**Planning Department
Transportation Development Services**

November 20, 2014

Re: Gorman Warehouse, 1330 12th Street NW
Traffic Circulation Layout
Architect's Stamp dated 11-17-14 (J13-D100)

EXISTING SITE PLAN

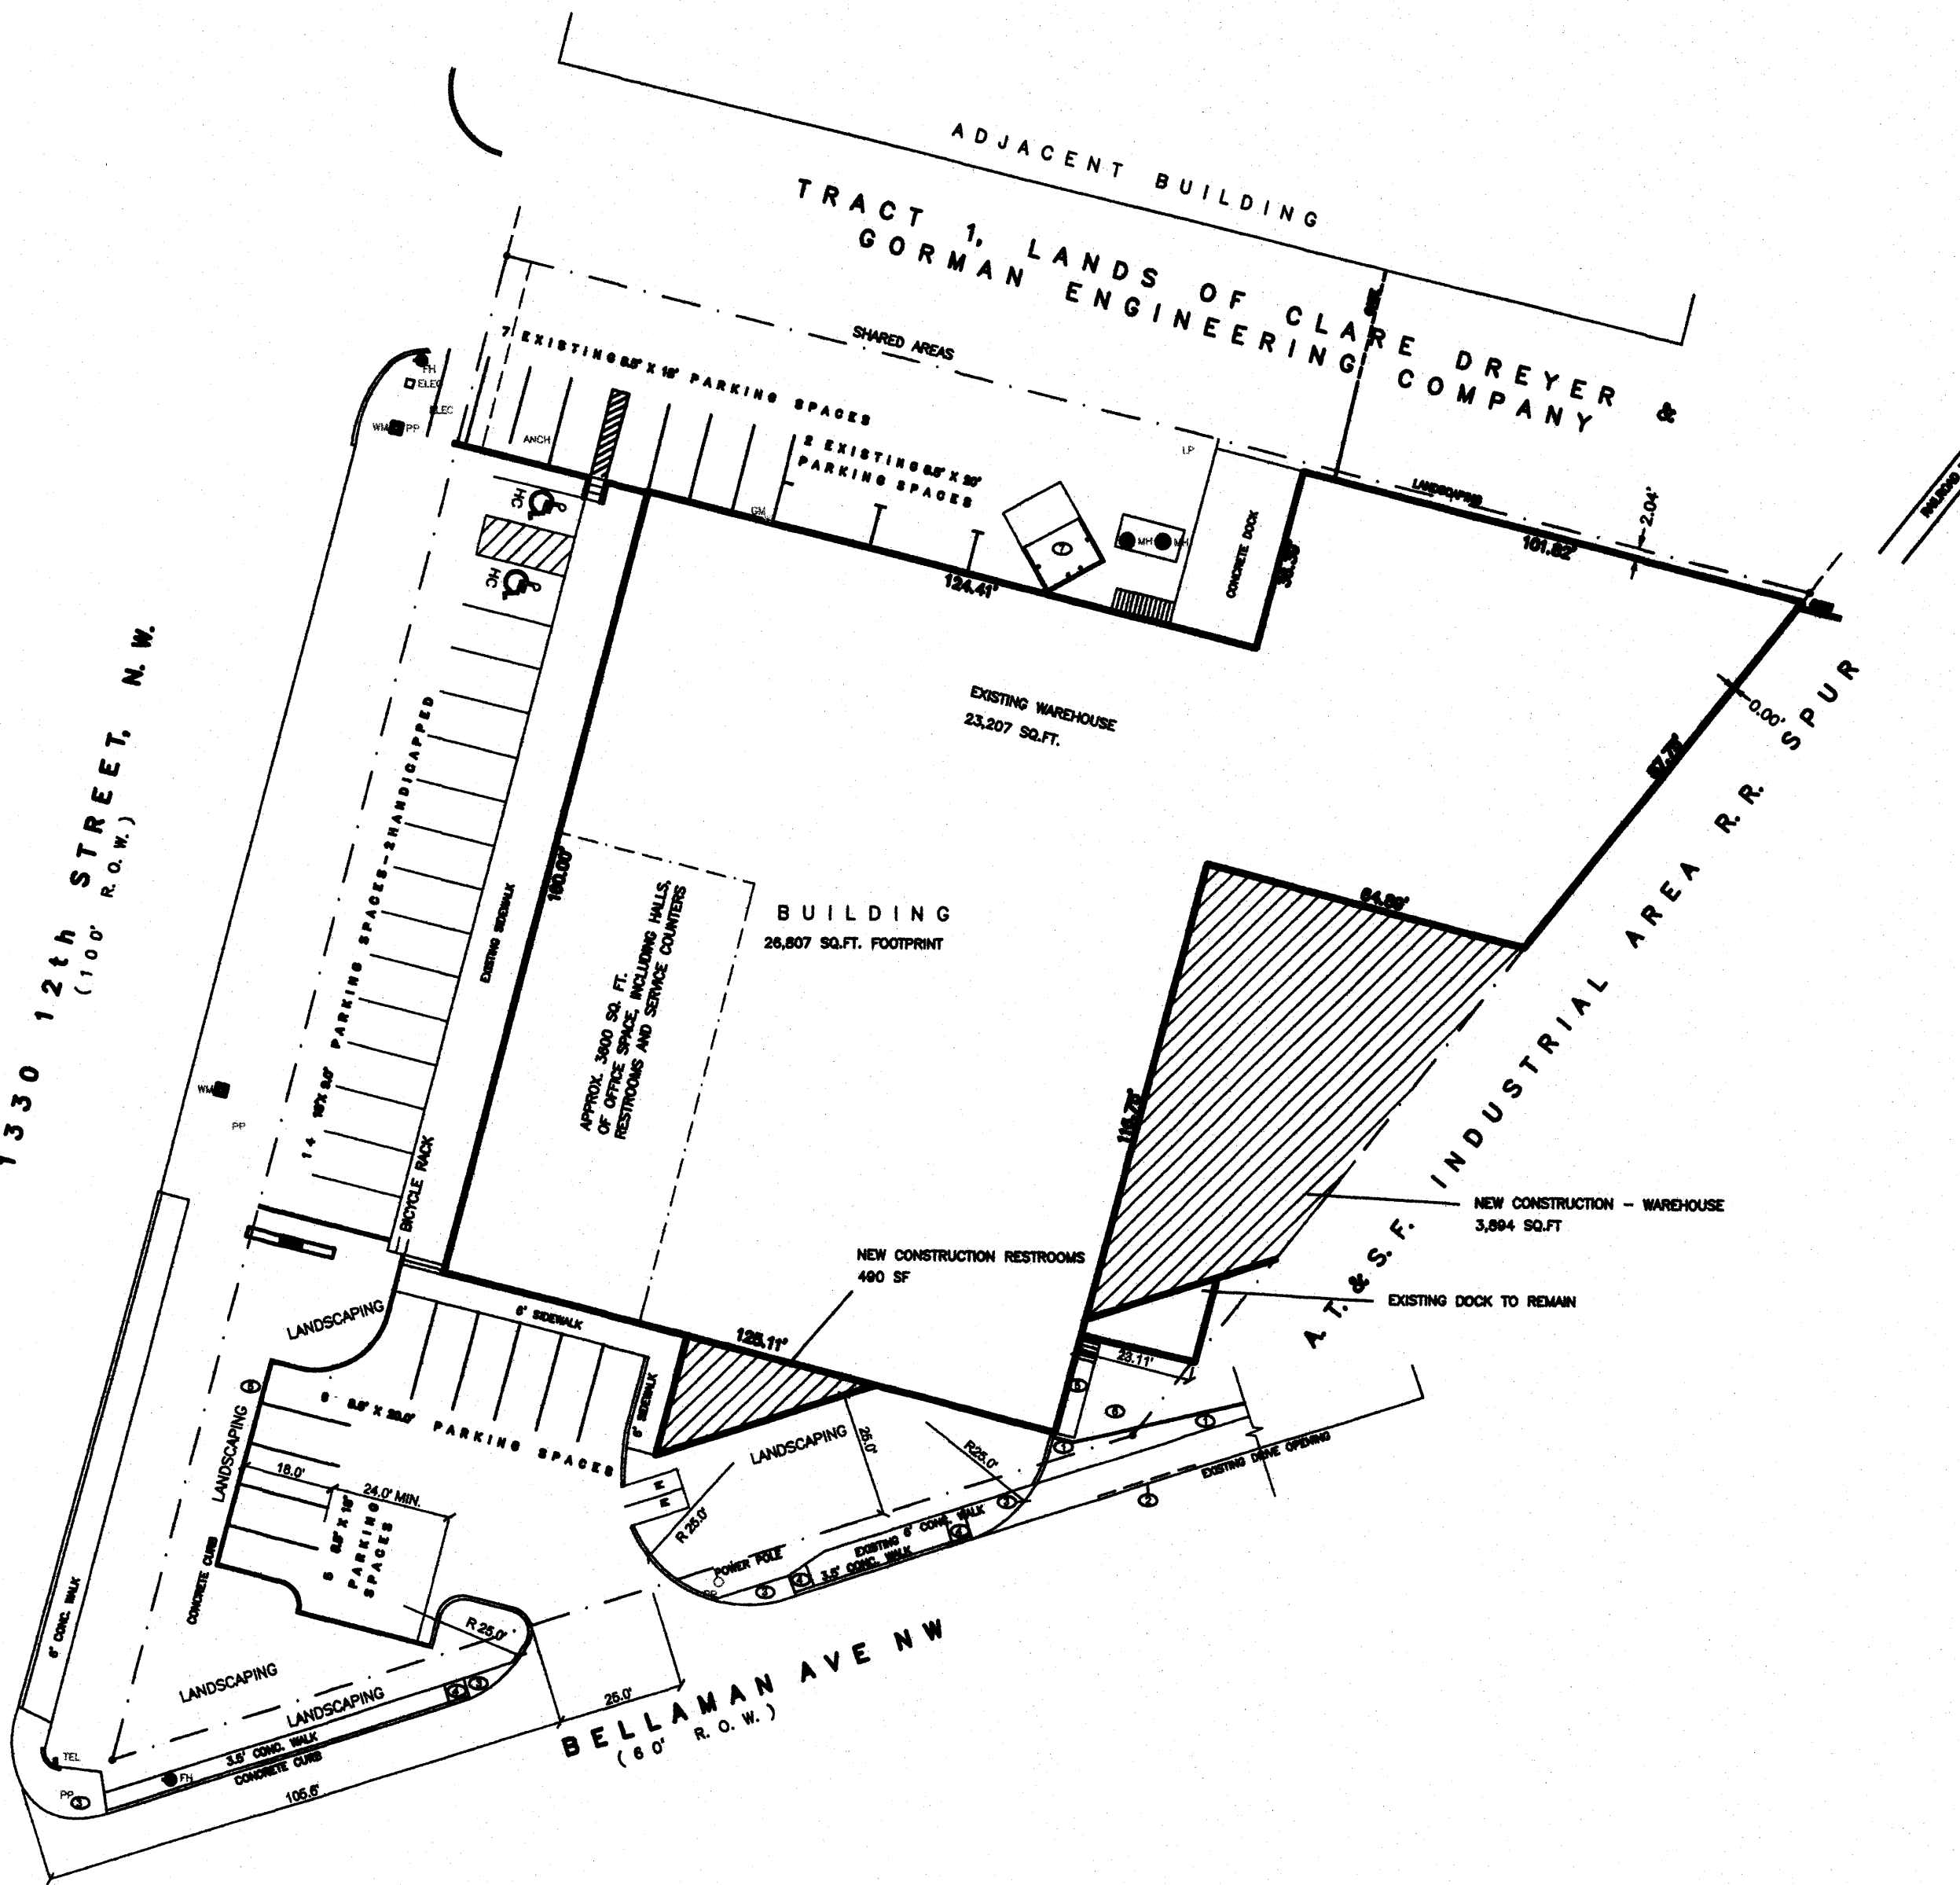
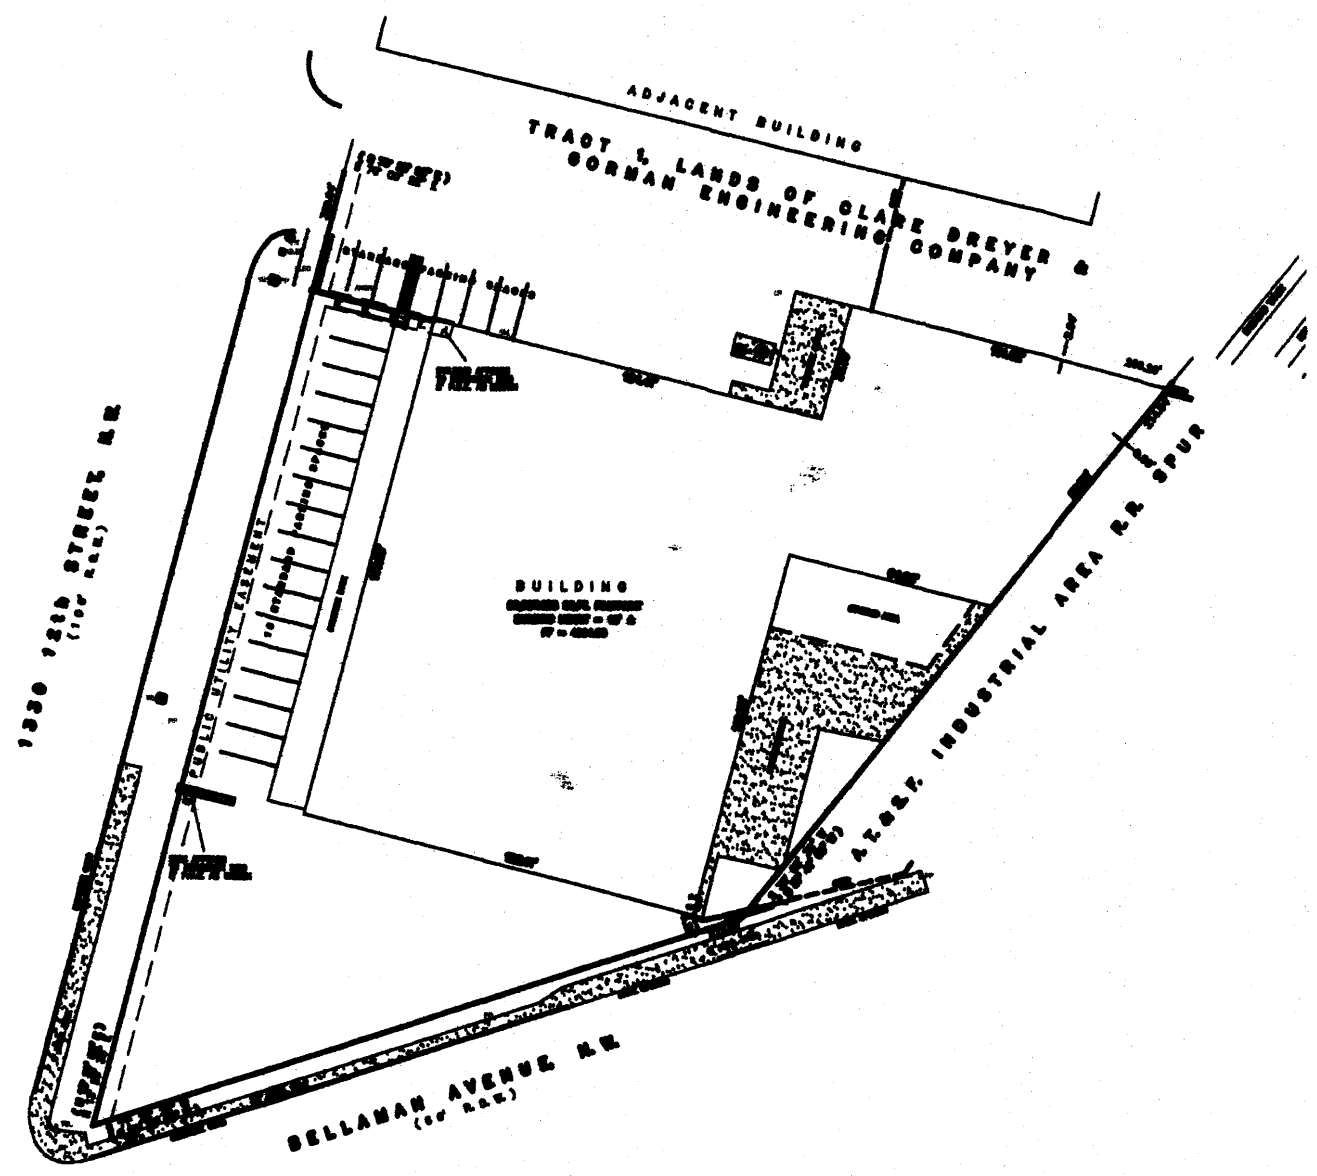
1. On the "Existing Site Plan", provide text that calls out the existing parking spaces on both the west and north side of the building for clarification.
